Mr Matthew Rosel  
Consultant Planner  
Key Sites Regional Assessments  
Department of Planning and Environment  
GPO Box 39  
Sydney NSW 2001

**Response to Submissions for Section 96 (1A) Modification, One Carrington,  
Sydney (SSD 5824 MOD 1)**

DRAWINGS  
L-000 COVER SHEET  
L-100 PUBLIC DOMAIN CONCEPT PLAN  
L-110 PUBLIC DOMAIN MATERIALS

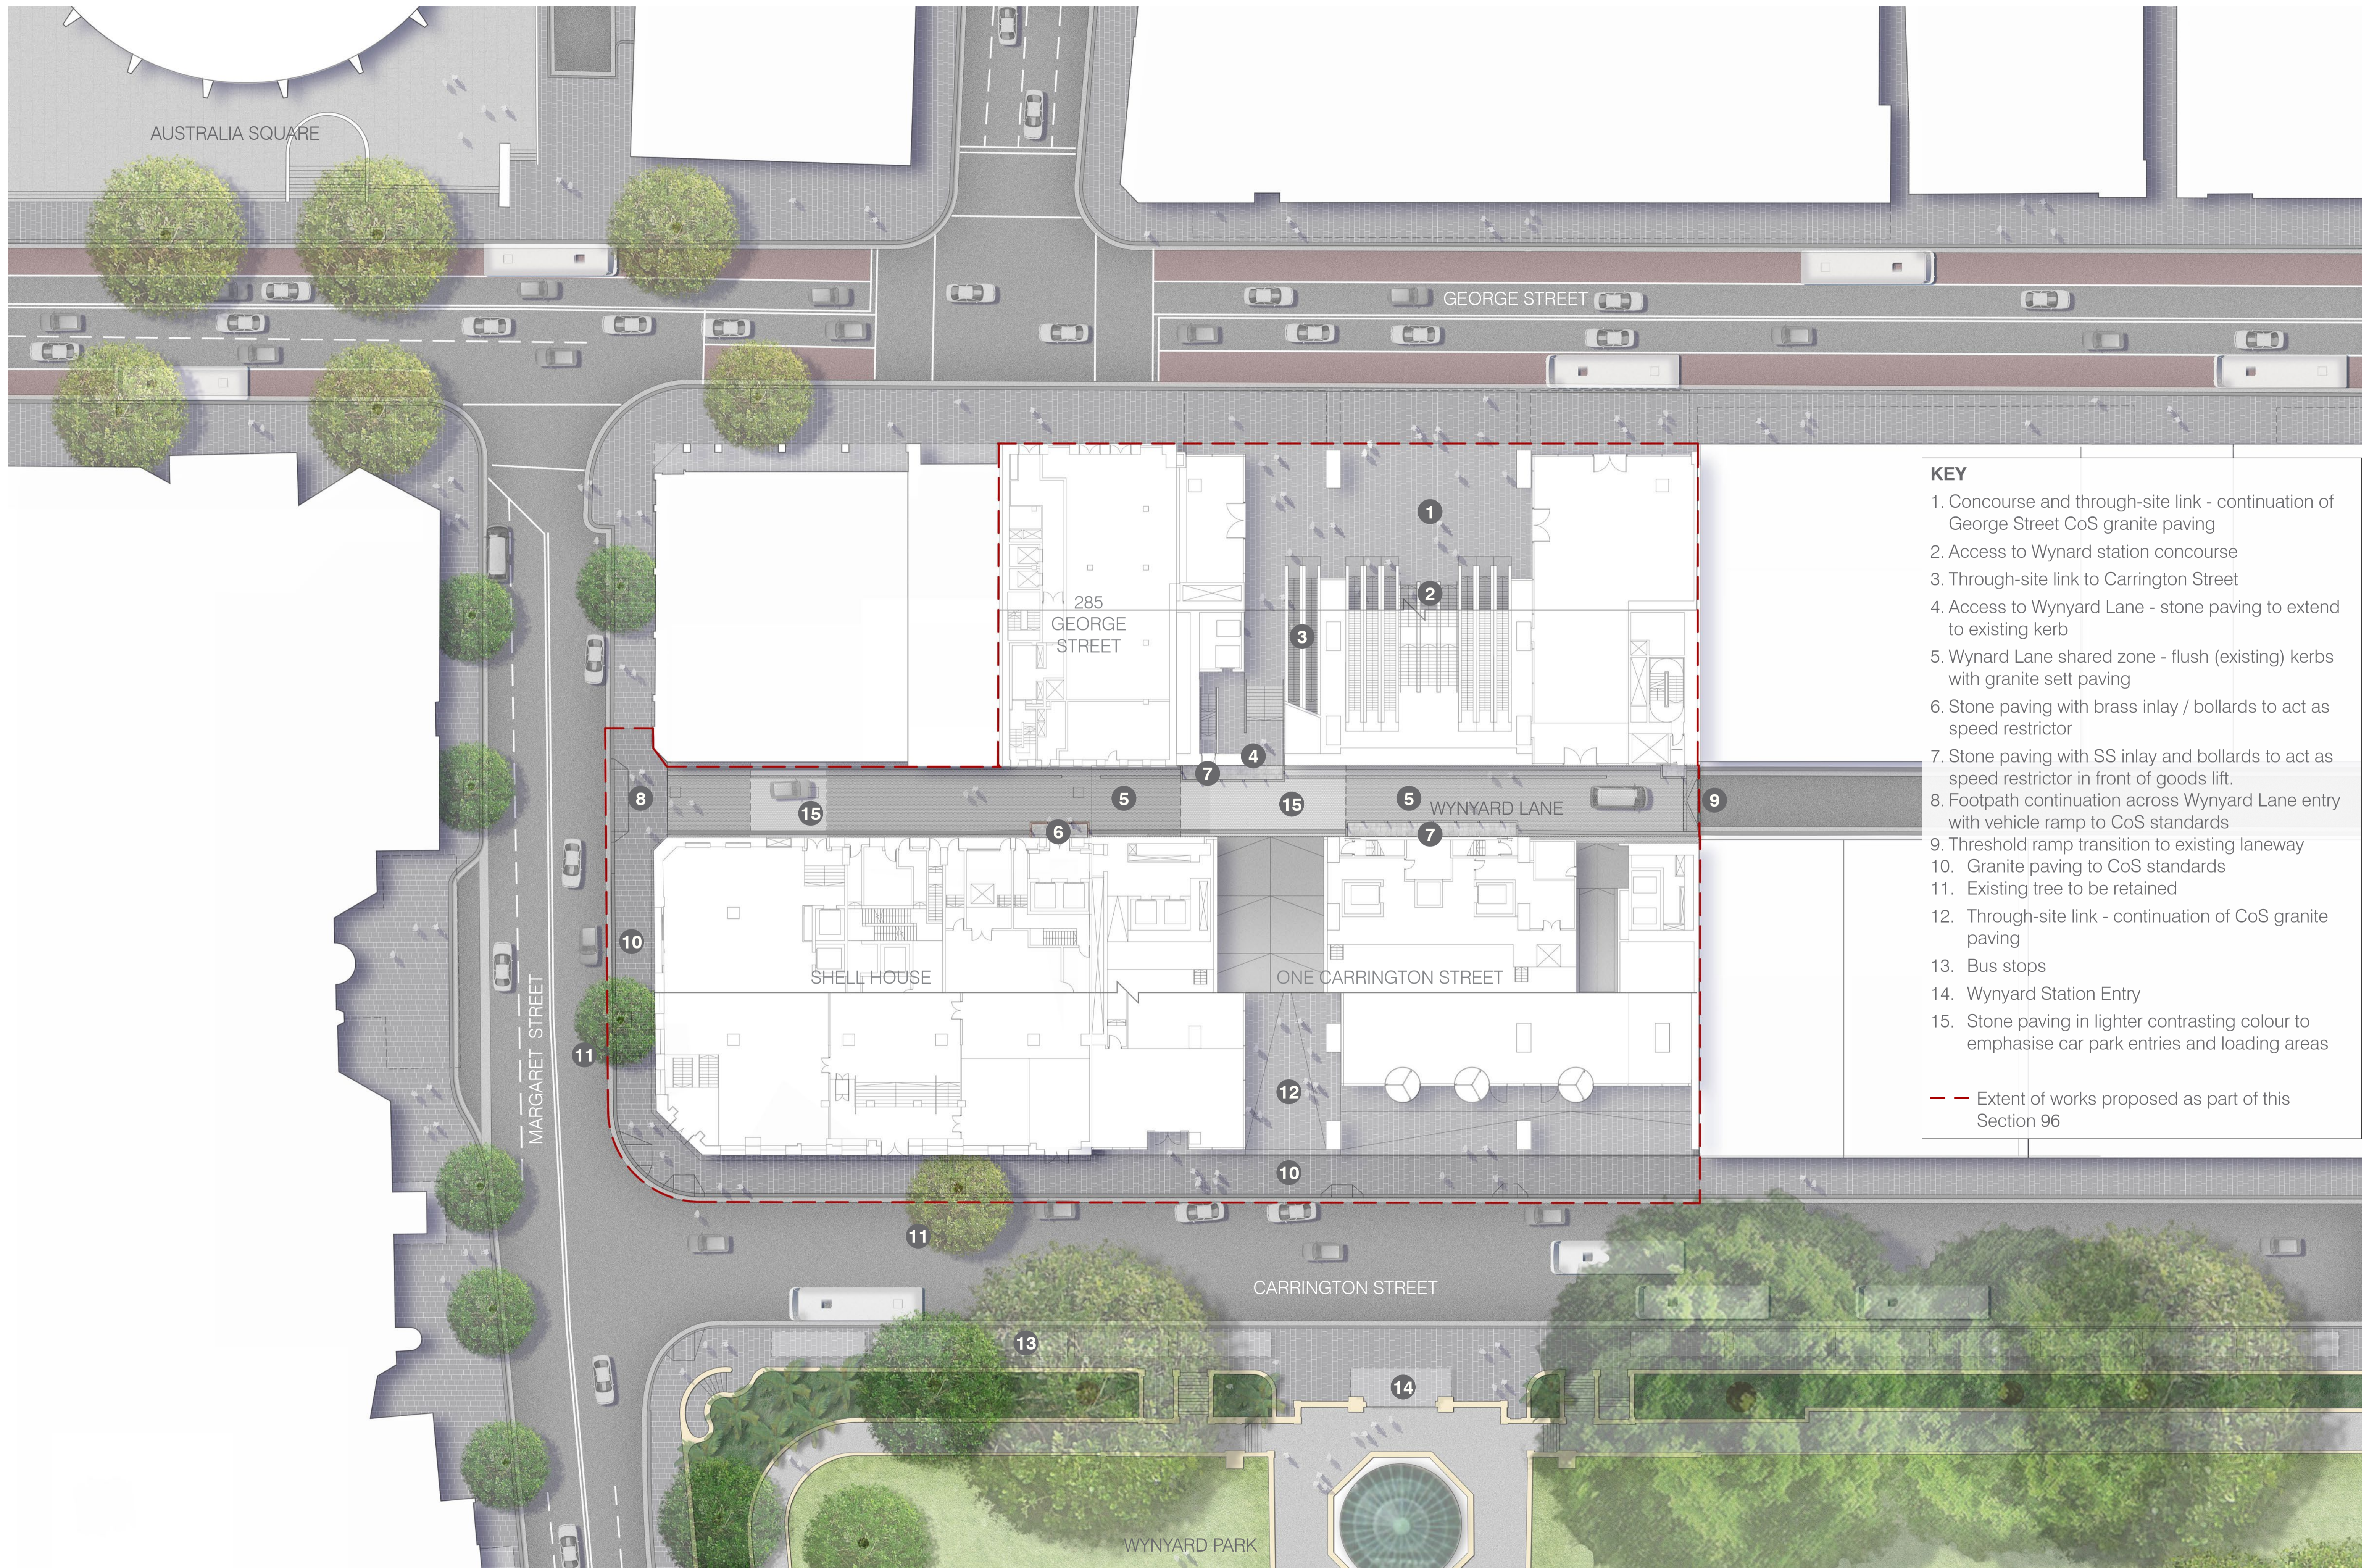
- The revised Public Domain Concept Plan (PDCP) prepared as part of the modification proposal includes a 3.5m wide central trafficable lane. It is not clear from the concept plan whether the proposed 3.5m wide traffic lane and 1.3m wide pedestrian lanes on both sides of Wynyard Lane will be delineated with line marking. TfNSW requests that line marking be provided to guide vehicles to travel along the proposed 3.5m wide lane.

- Wynyard Lane is estimated to carry more than 100 vehicles in an hour to access One Carrington development, the public car park and 275-281 George Street during peak periods. Based on TfNSW SS/12/01 shared zone policy, if a road section carries more than 100 vehicles in an hour it is not suitable for a shared zone. Therefore, TfNSW requests that the applicant consult with Roads and Maritime Services and the Centre for Road Safety in relation to shared zone requirements.

- If Roads and Maritime Services and the Centre for Road Safety agree that a shared zone along Wynyard Lane can be implemented, then a 10km/h speed limit within the shared zone would be appropriate in accordance with the aforementioned shared zone policy.

- The turning paths of vehicles at the access to the One Carrington car park/loading dock and the public car park would encroach onto the proposed 1.3m wide pedestrian zone.
- Safety concerns due to multiple vehicle movements with limited sight distances to pedestrians at the driveways along Wynyard Lane.
- Potential pedestrian/vehicle conflicts at the proposed pedestrian entry to Wynyard Lane opposite the One Carrington development loading dock and car park access.

Based on the above, TfNSW requests that the applicant be conditioned to undertake a Stage 2 (Concept Plan) Road Safety Audit, in accordance with Austroads *Guide to Road Safety Part 6: Road Safety Audit* by a TfNSW accredited road safety auditor. Based on the results of the road safety audit, the applicant needs to review the design drawings and implement safety measures as required.

*“Prior to the issue of the relevant Construction Certificate, the applicant shall undertake a Stage 2 (Concept Plan) Road Safety Audit for the proposed changes along Wynyard Lane as provided in the revised Public Domain Concept Plan (PDCP), in accordance with Austroads Guide to Road Safety Part 6: Road Safety Audit by an independent TfNSW accredited road safety auditor. Based on the results of the road safety audit, the applicant shall review the design drawings and implement safety measures as required.”*
